June 2, 2017

City of Albuquerque
Planning Department
Current Planning Section

Re: Environmental Planning Commission
Project#: 1011188, case #17EPC-40007 May 11 – Site Development Plan for Building Permit

**LANDSCAPE DETAILS
NTS**

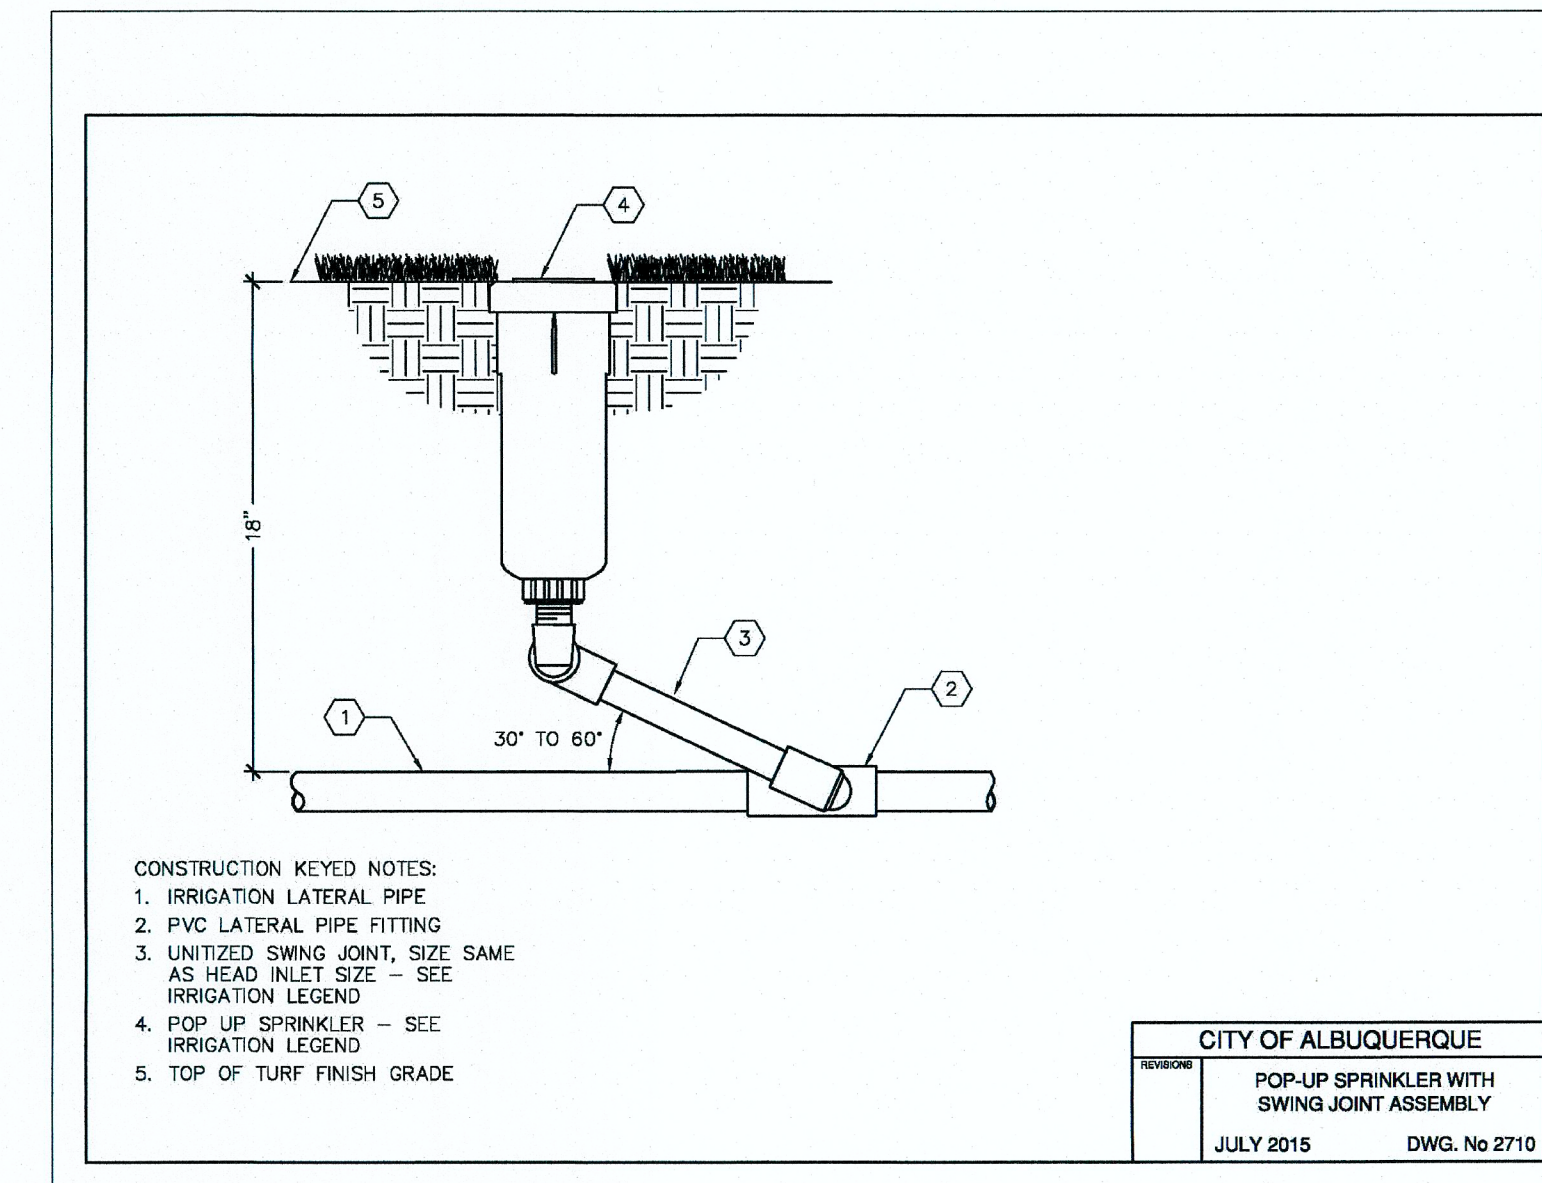
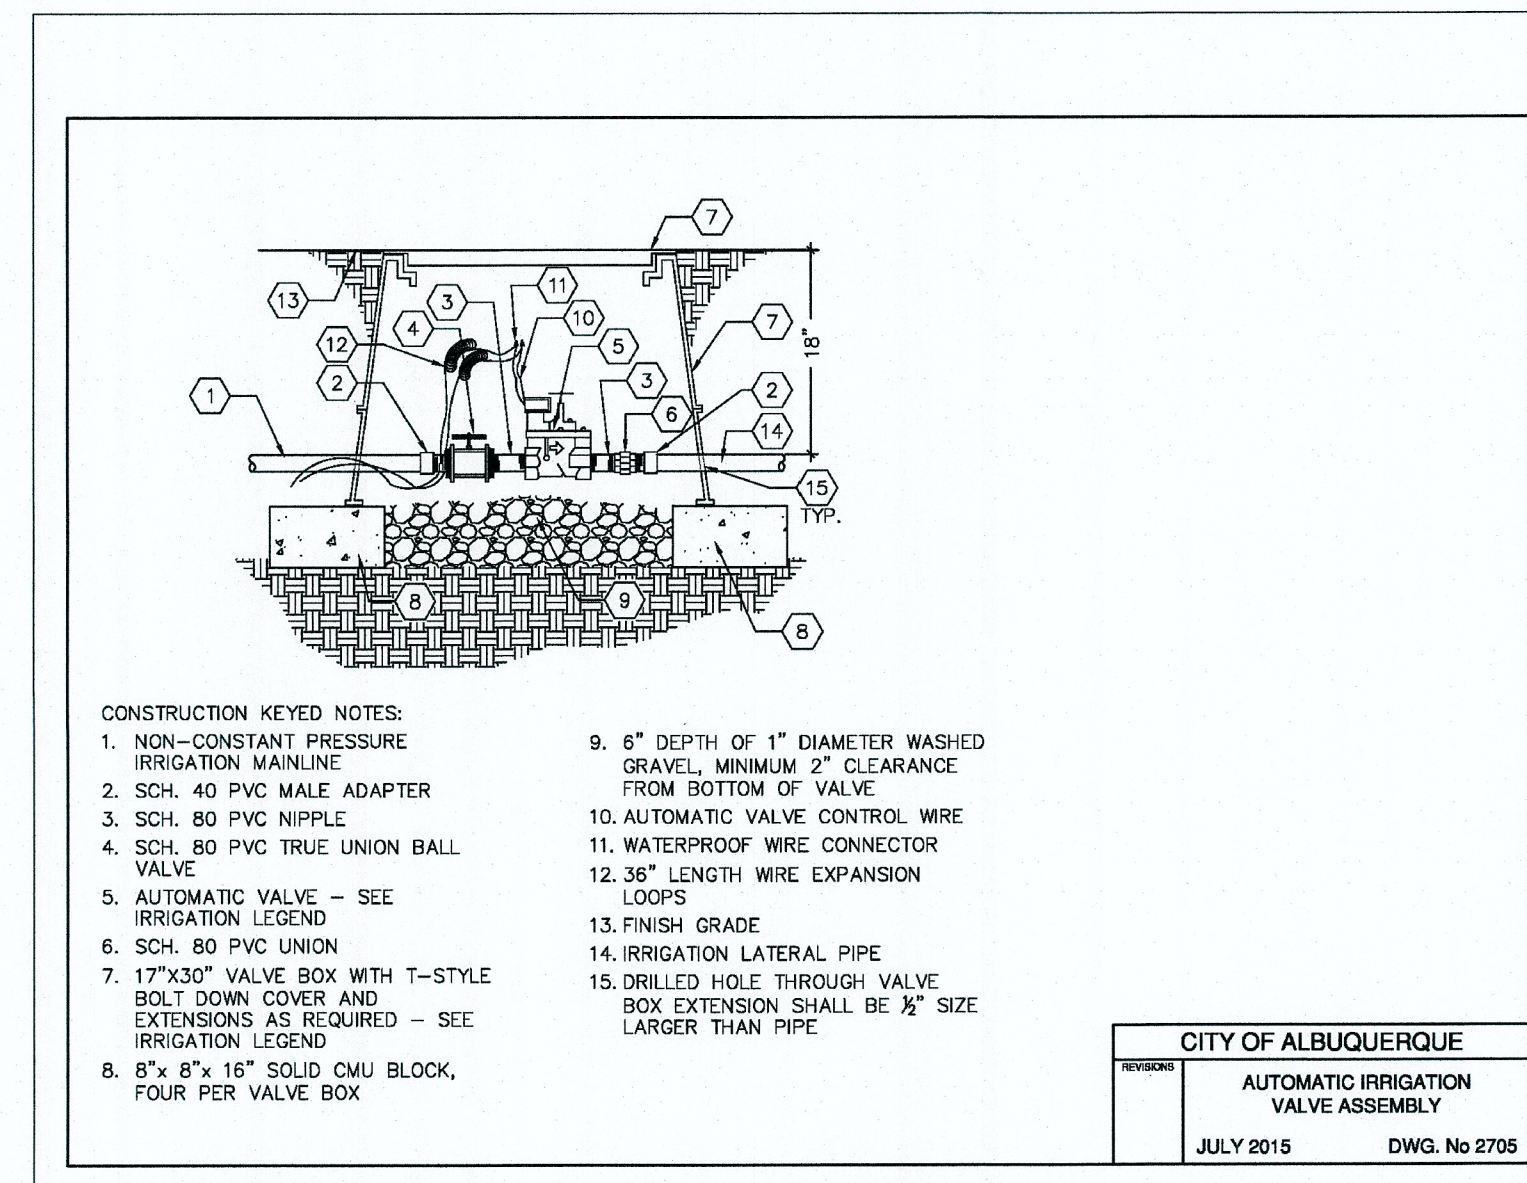
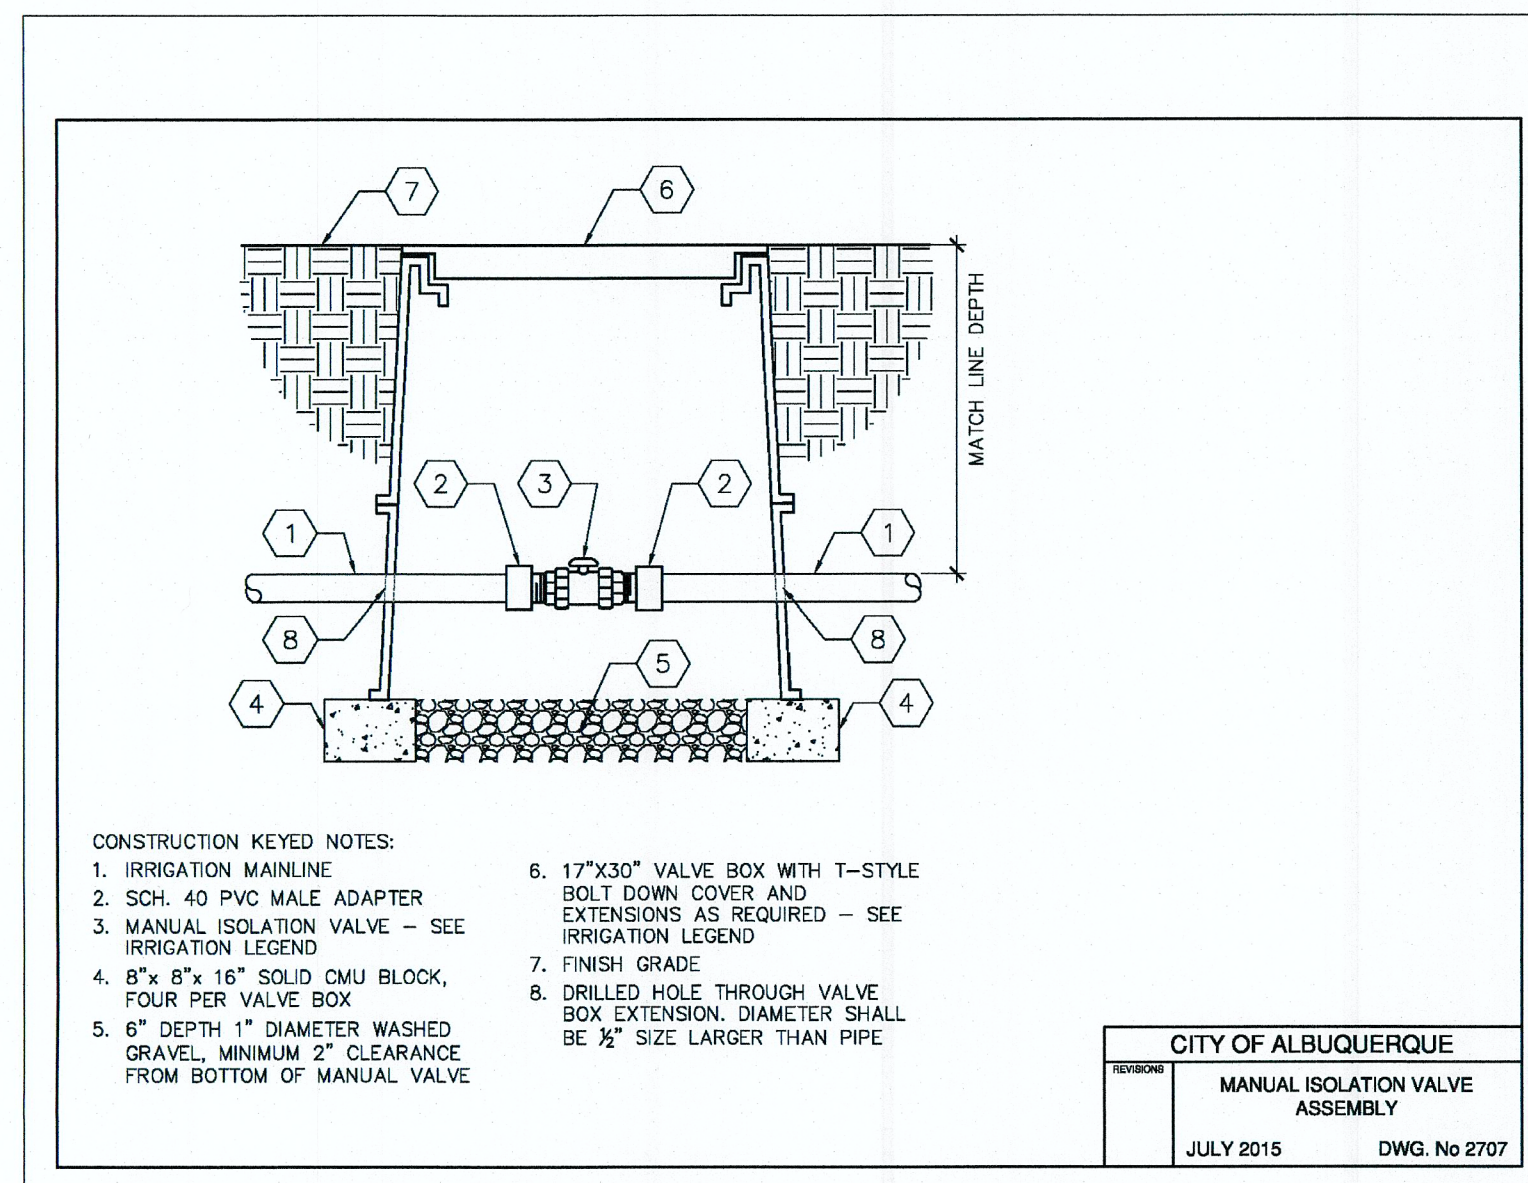
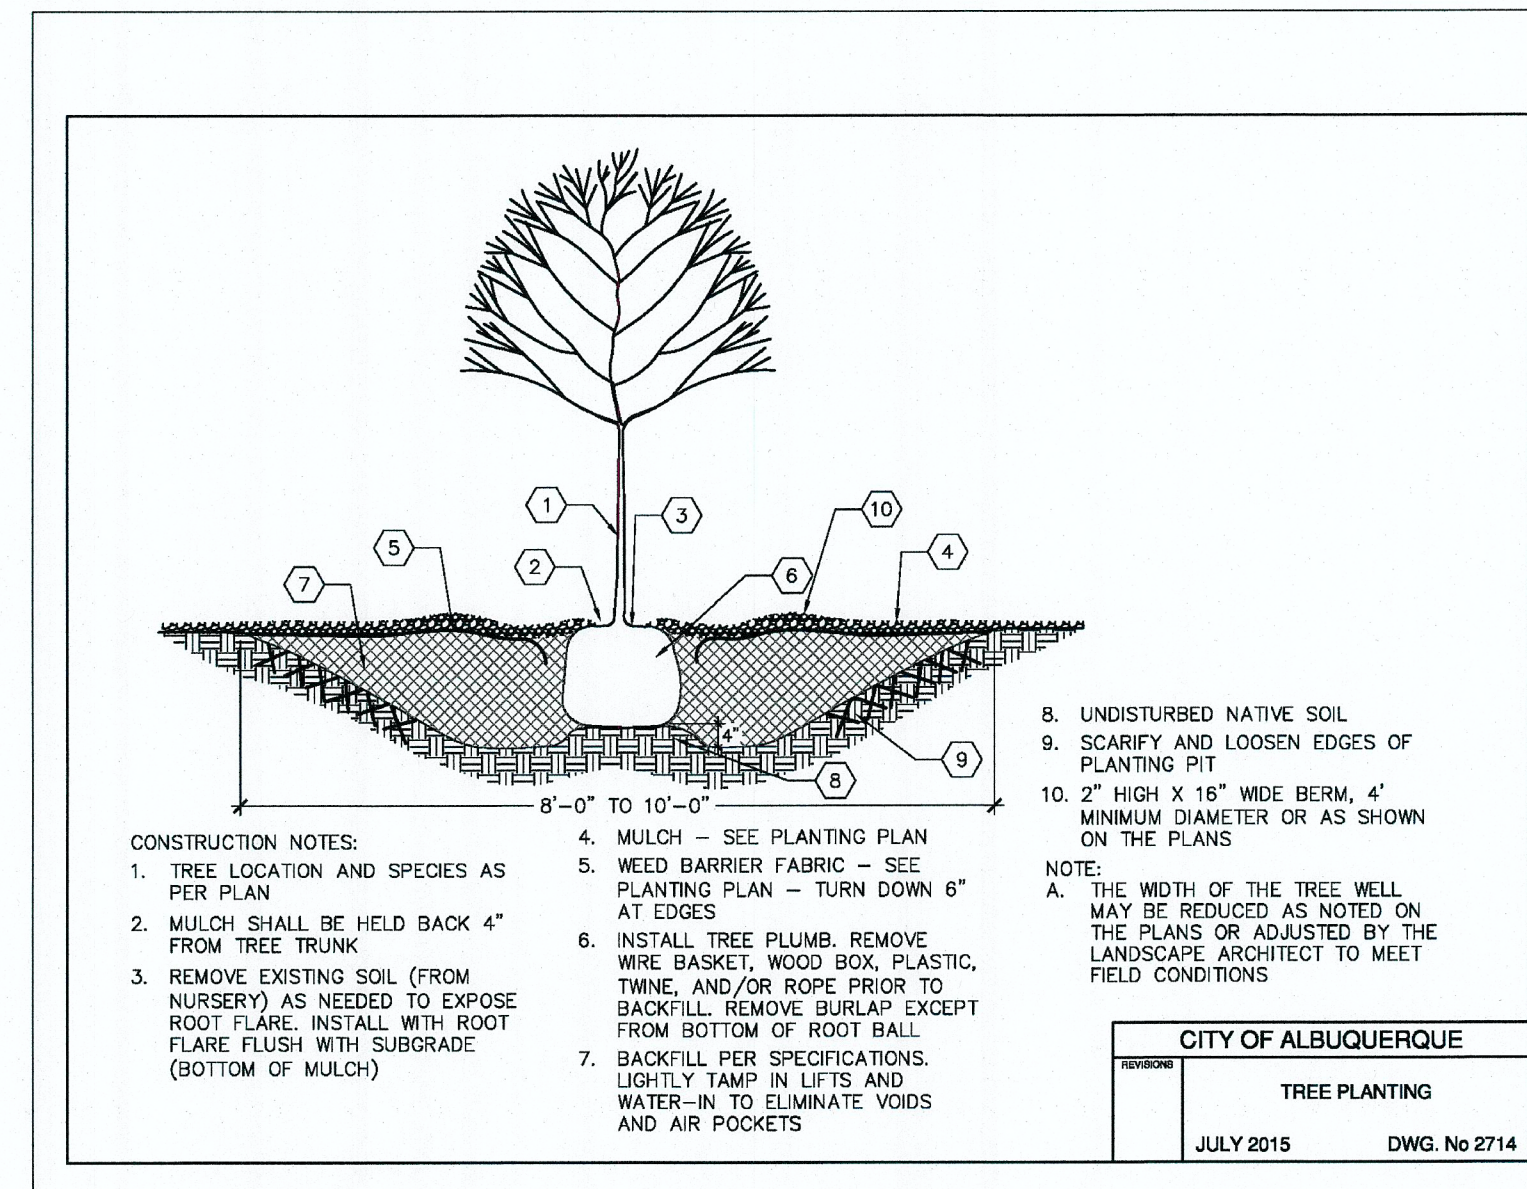
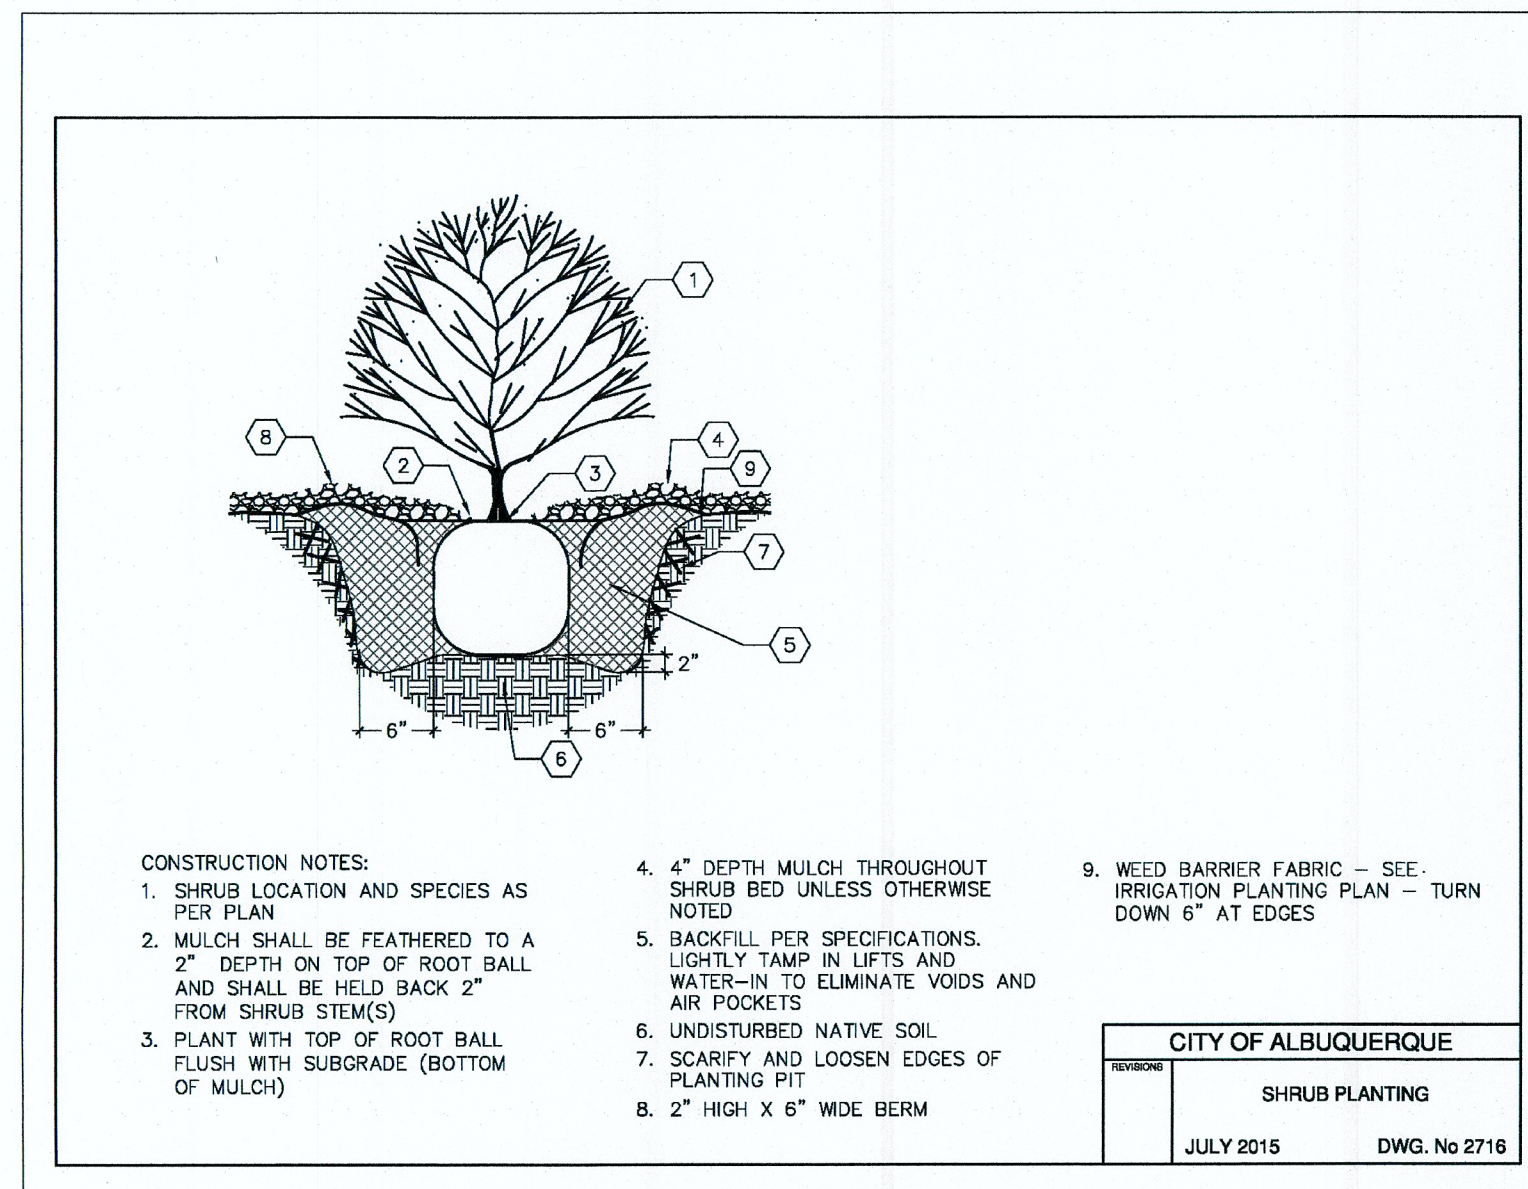
Comment Number 12. A note has been added to indicate that the landscape on the western and southern landscape will be irrigated or hand watered. A new sheet L2 has been added that has notes and details for planting and irrigation.
